RFI

RFI #: 4
 Date: 12/1/2011
 Job: EB-02 Keller Springs Lofts
 Phone: 877-777-5115

Subject: RFI #4

5.5B

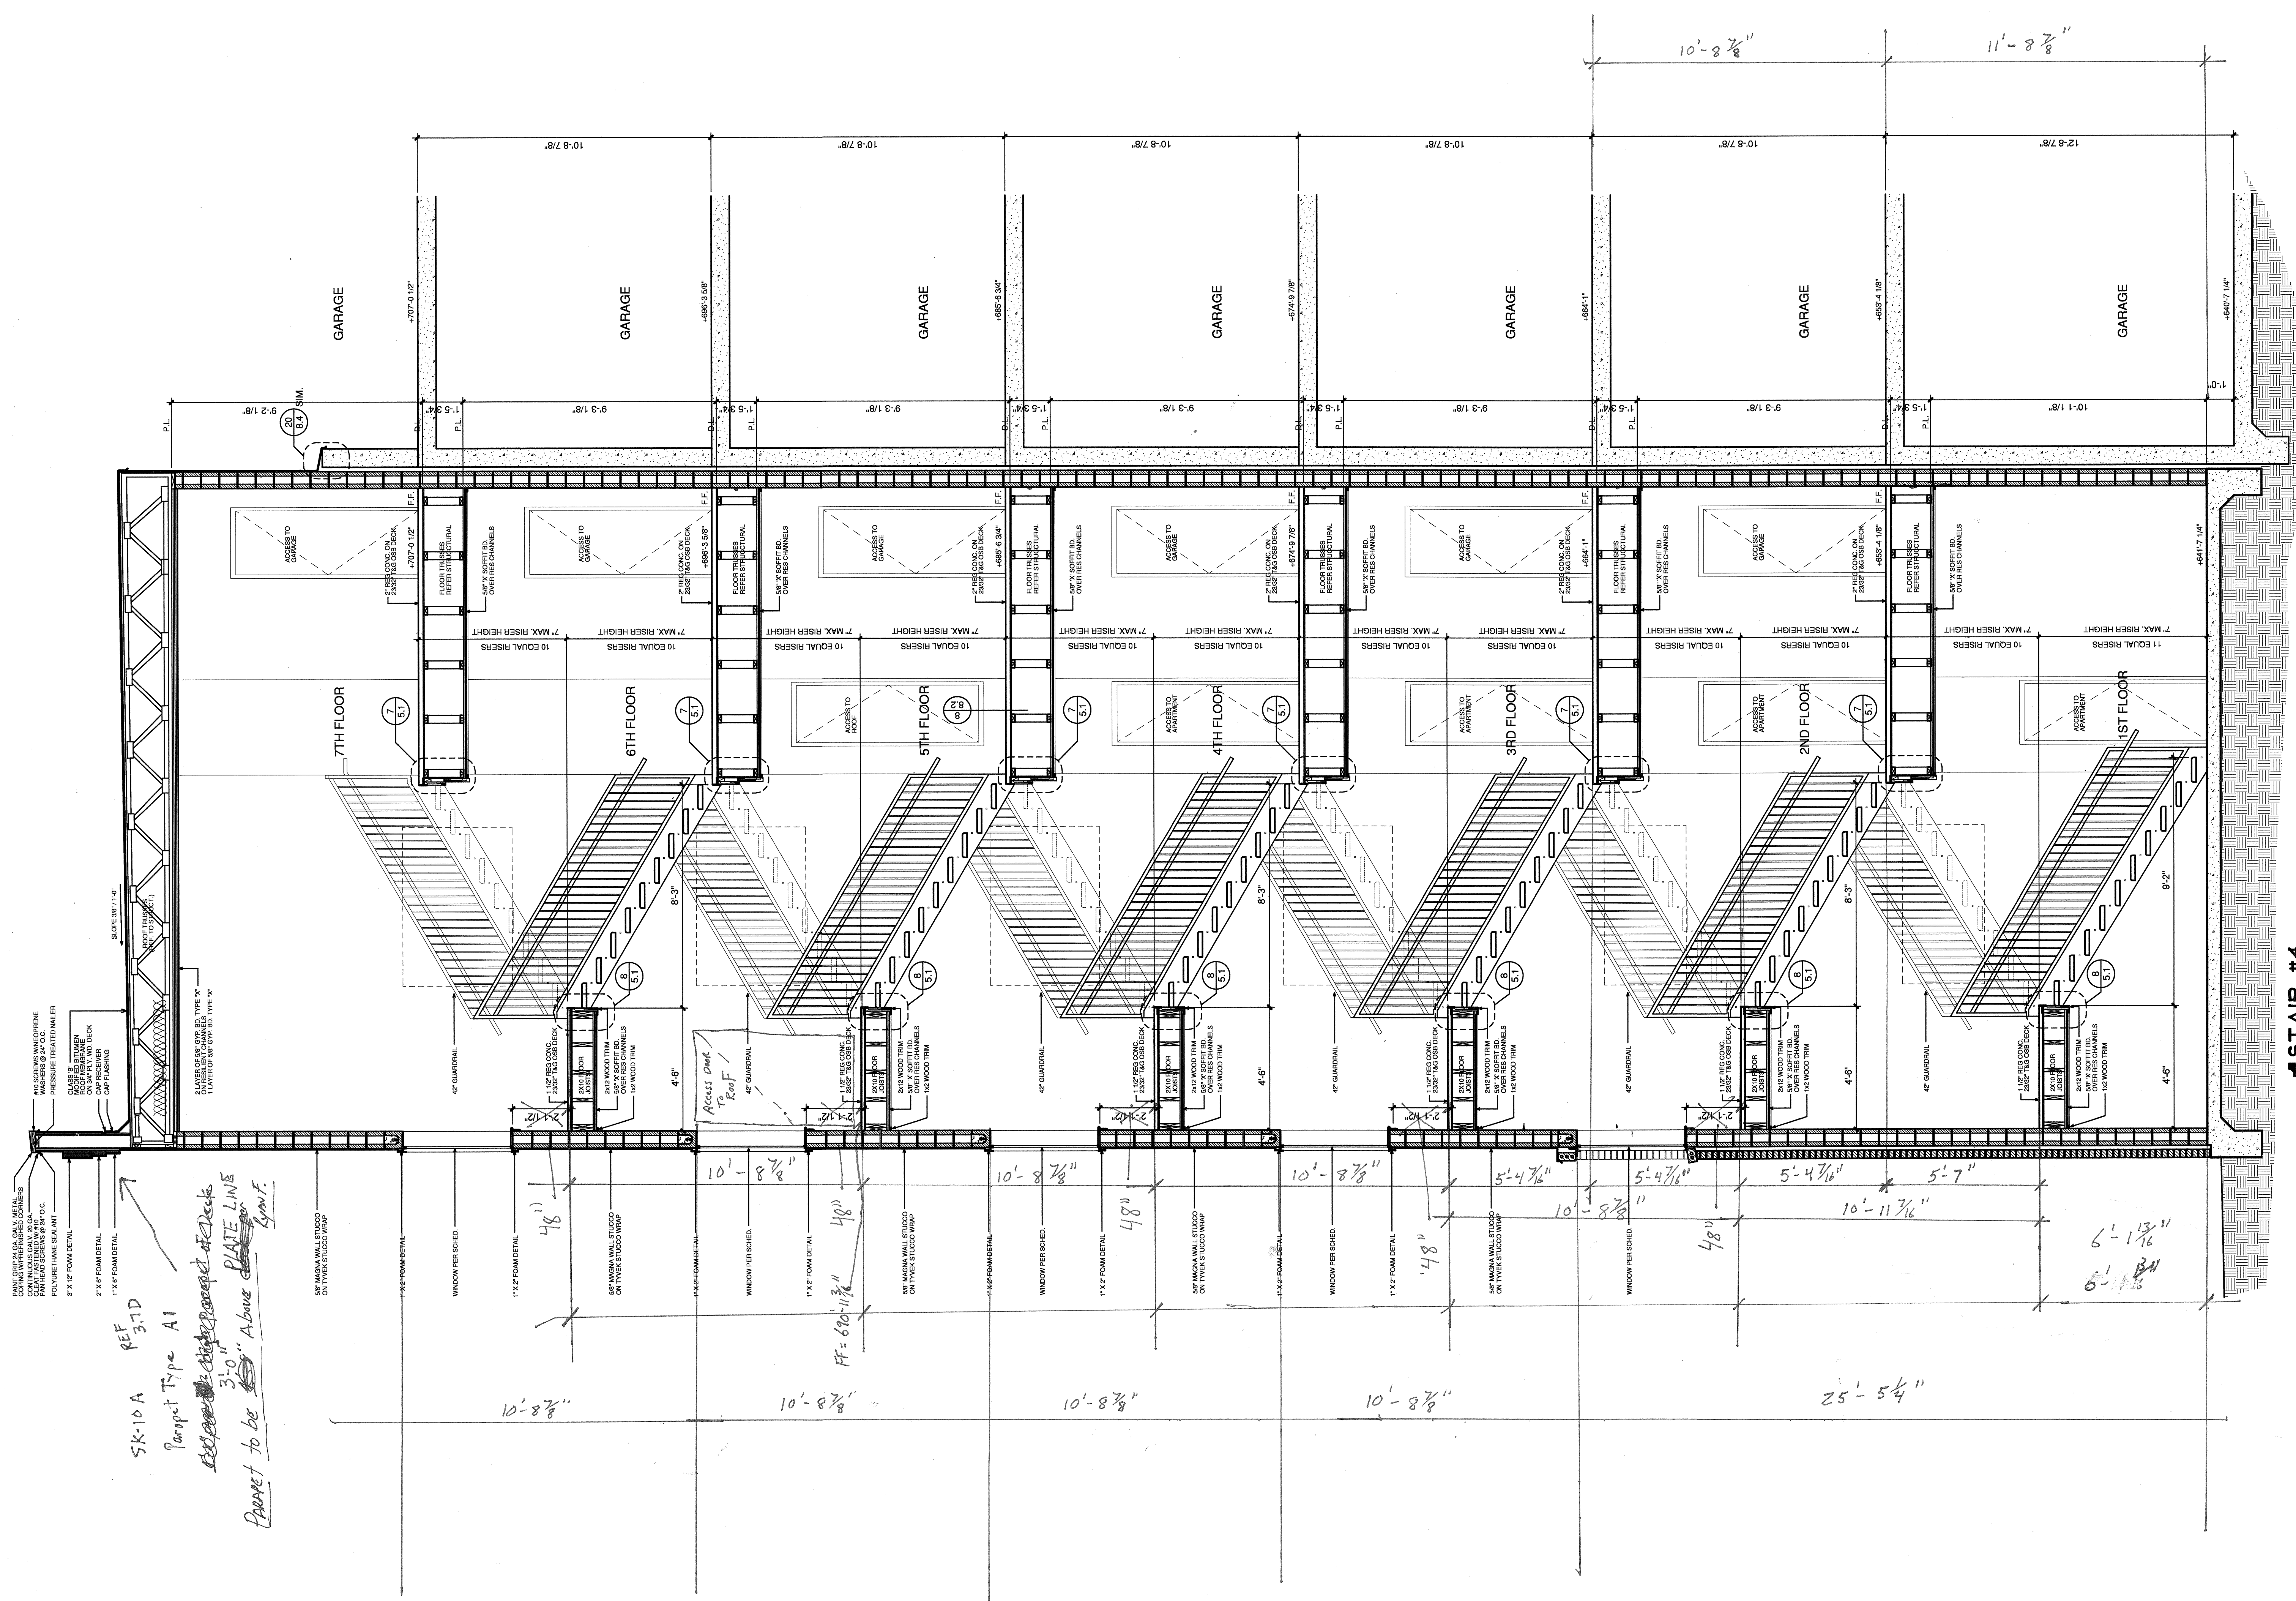
Subject: RFI# 6 stair #4 detail

Request: Please provide detail for door and location going to roof on sheet 5.4 also provide sheet detail of stair #4 Also please provide same information for stair #5 Date Required: 12/8/2011

PLEASE SEE THE ATTACHED SHEETS WITH STAIR SECTION #4 AND #5

THE ROOF TOP DOOR DETAILS HAS ALWAYS BEEN LOCATED ON 8-8.2 AND KEYED ON THE ROOF PLAN 3.5D. AS SHEET 5.5B IS NEW TO THE SET I HAVE ADDED IT TO THE INDEX AS WELL
